From: Karpezo, Marta [REDACTED]
Sent: 30 June 2017 13:05
To: Anita Gardner; Planning.Responses
[REDACTED] Ward, Stuart
Subject: Re: CRL Littlehampton - 38-40 East Street & 35 Fitzalan Road, Littlehampton, Sussex, BN17 6AN - Sec 106
Sewer Connections Application
Importance: High

38-40 East Street & 35 Fitzalan Road, Littlehampton, Sussex, BN17 6AN

Section 106 FWS & SWS Sewer Connection Application

SW Ref : S106-009634

Ex Drainage Layout Plan (Extract of Dwg F2505/01) Scale 1:125

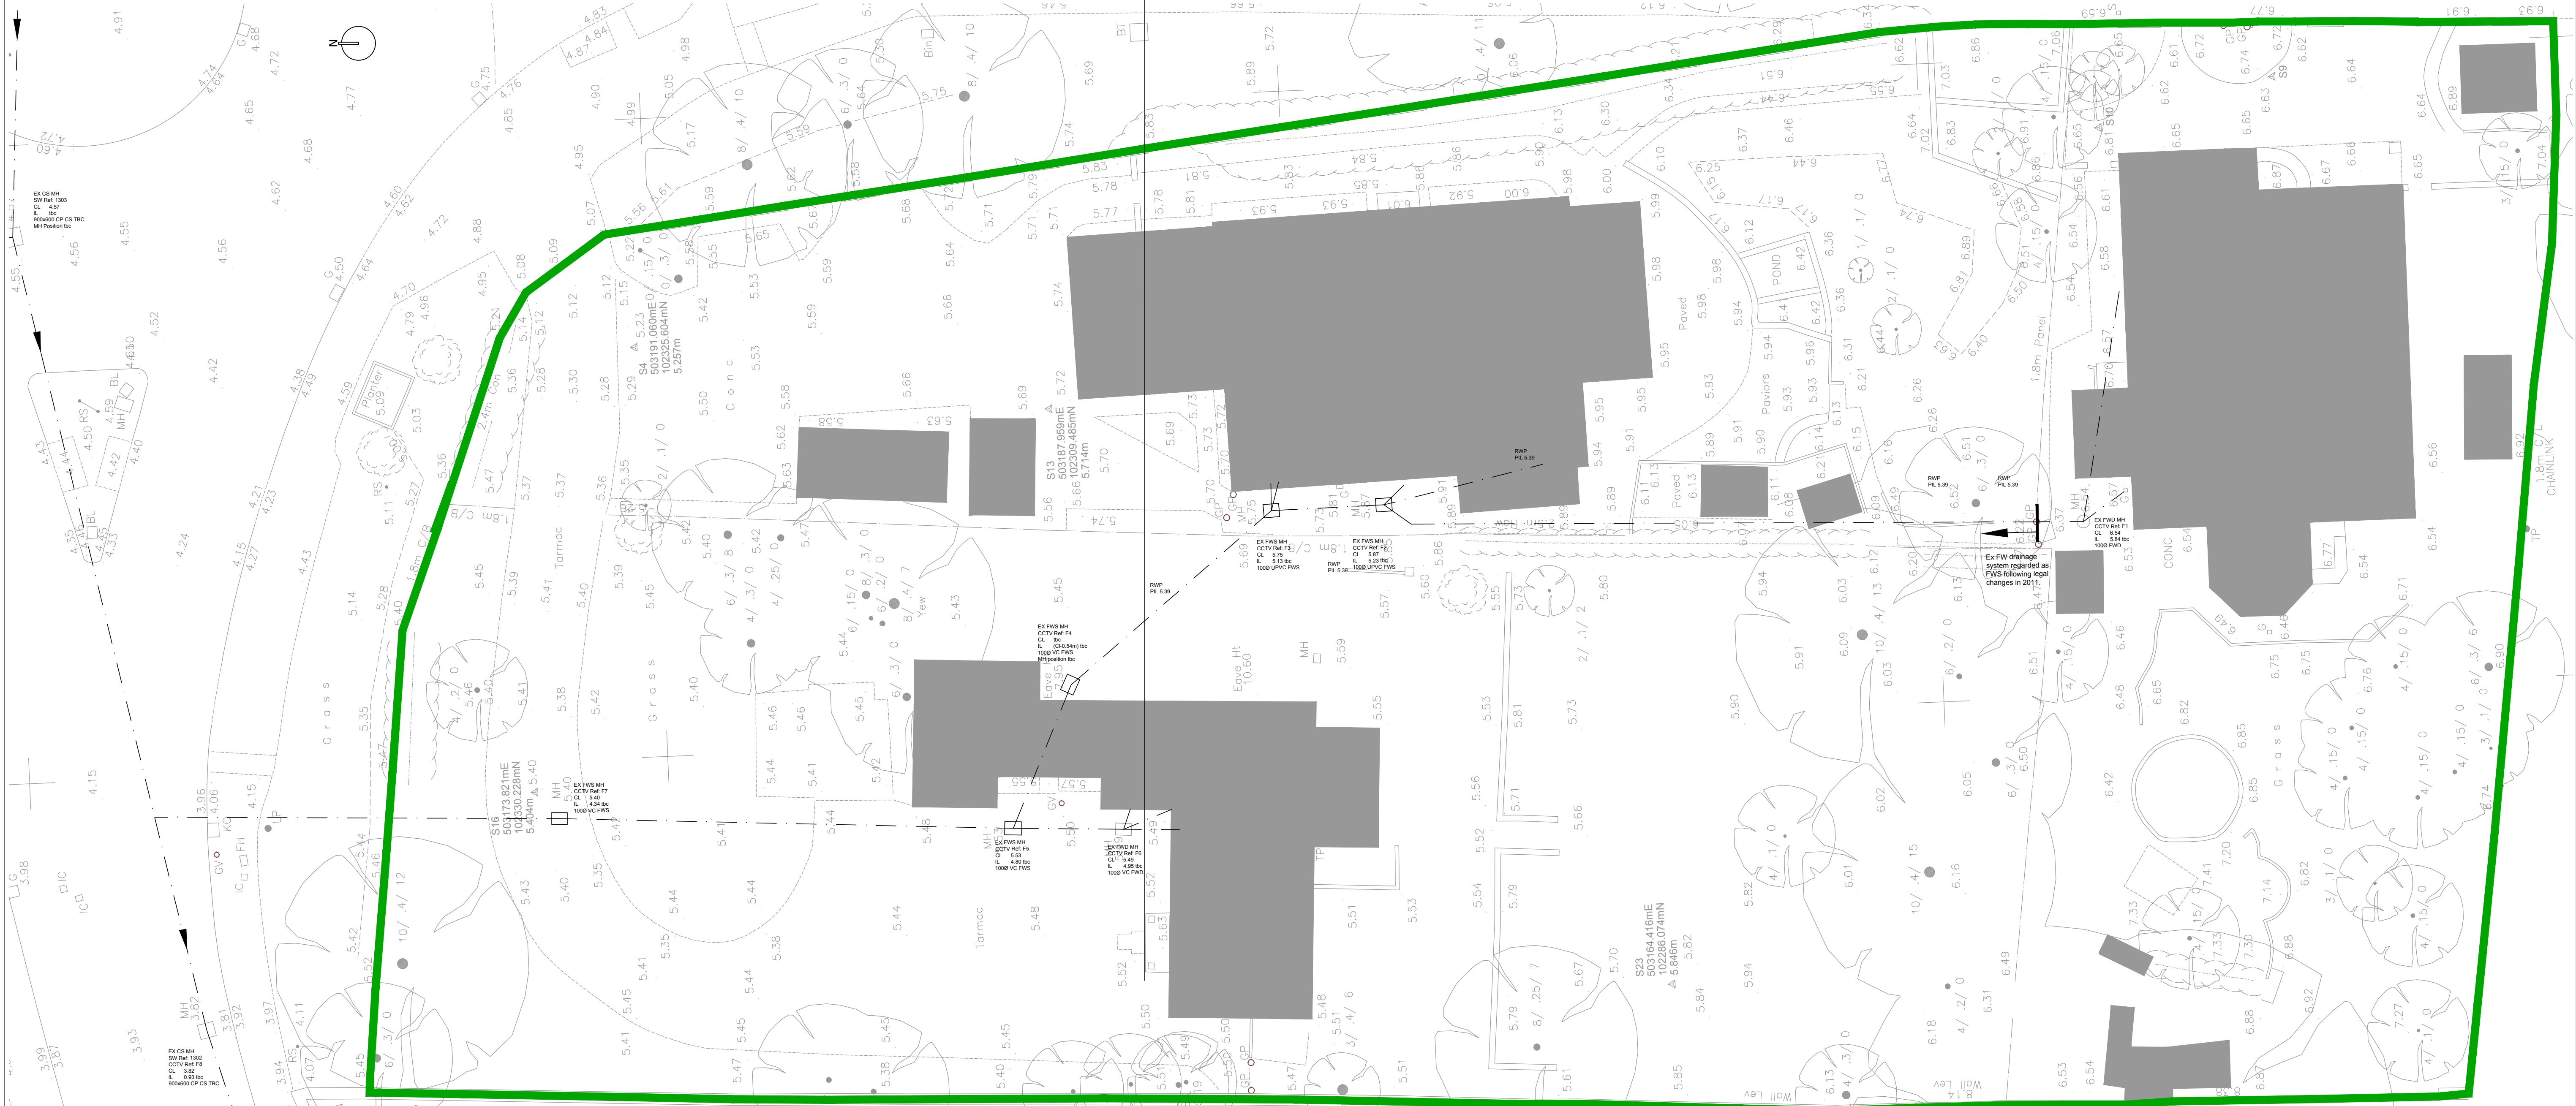
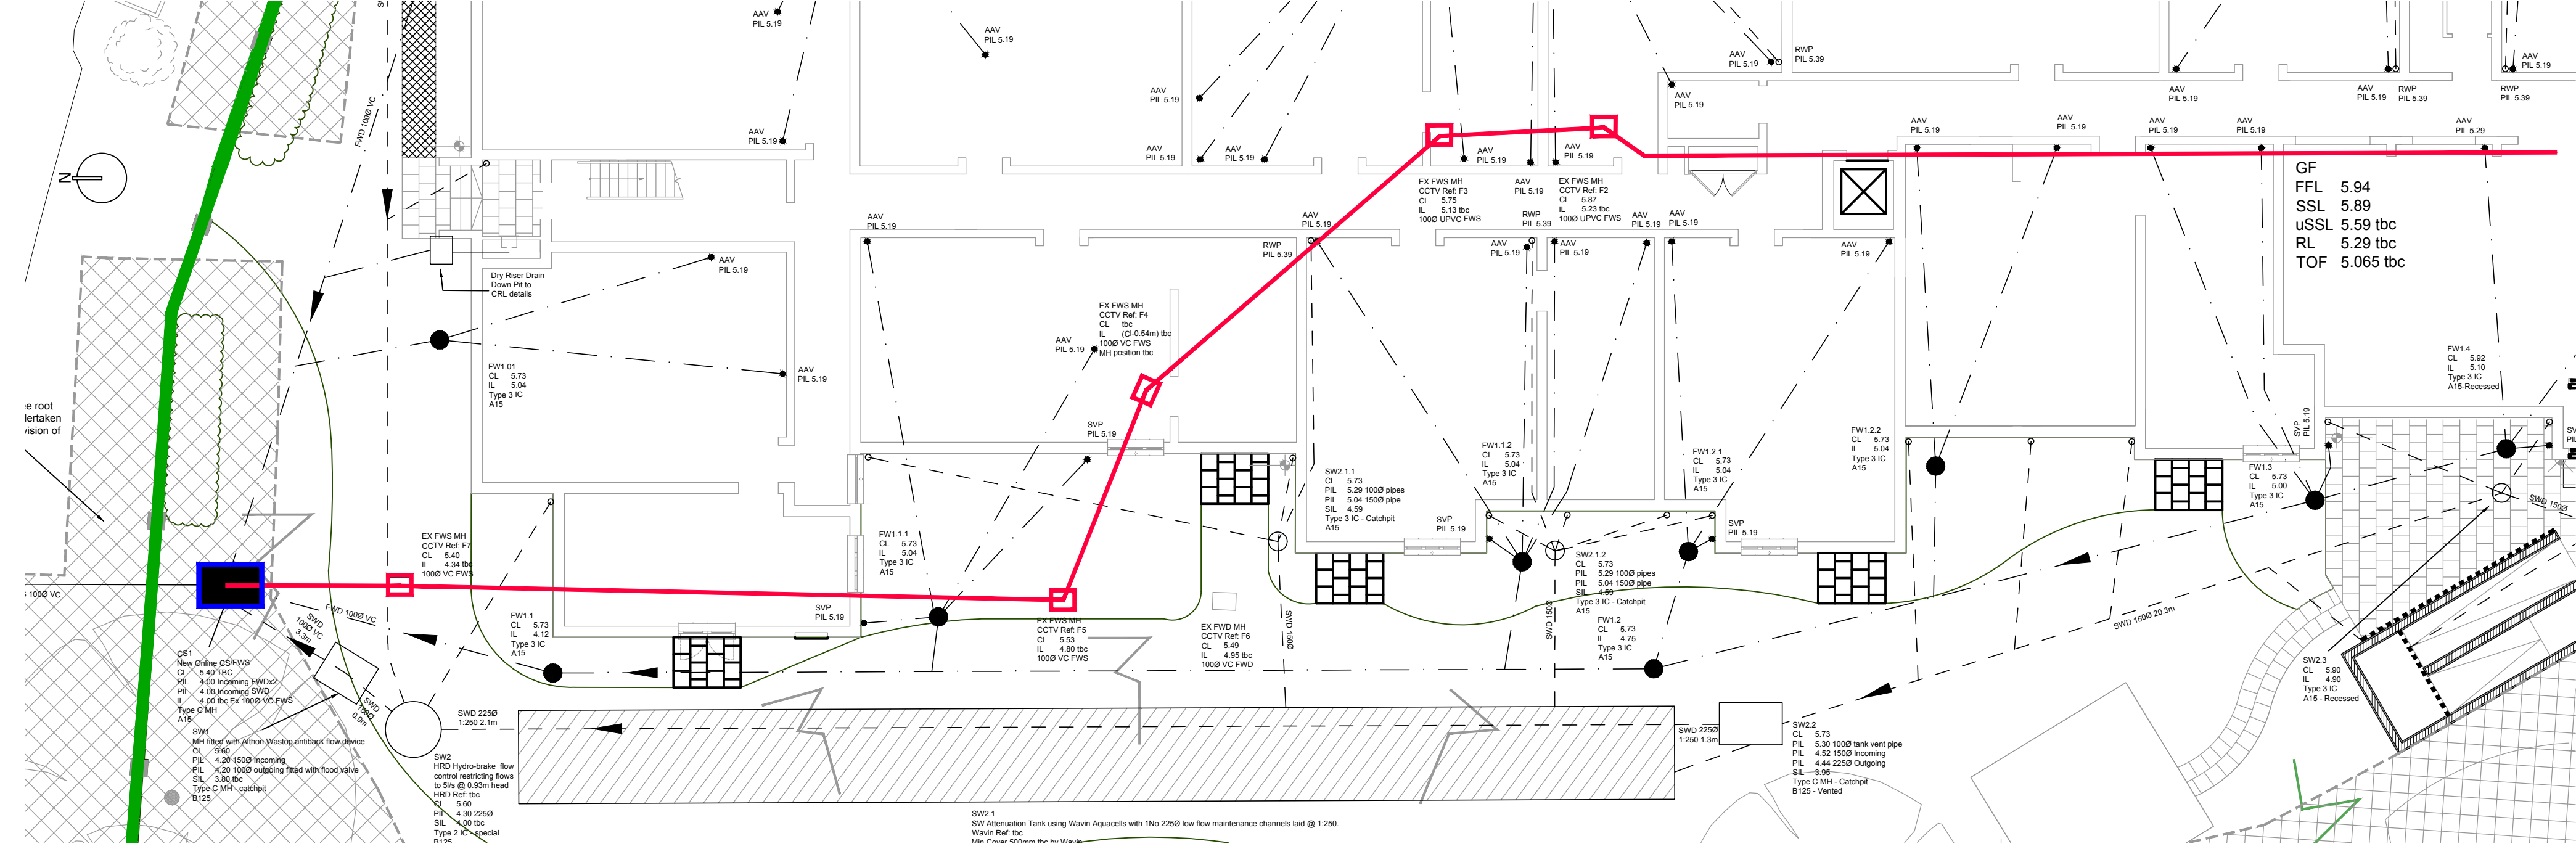
We are proposing a combined connection to an existing on site combined sewer.

Ex & prop Drainage layout attached

We therefore assume that the existing site had a combined discharge from site.

Existing Imp area is 1410 sqm, proposed area is 1610sqm

Note proposed flows restricted to 5l/s, whereas existing flows had no attenuation at all.

Further to the below request from the developer, Southern Water can confirm that the proposed discharge of surface water to public combined
Sewer is acceptable at restricted rates as proposed by the developer. The applicant has demonstrated the existing pre-development discharge of surface water
Run off and further to that the assessment carried out by Southern Water can confirm that also additional discharge at this flow rate would be acceptable.
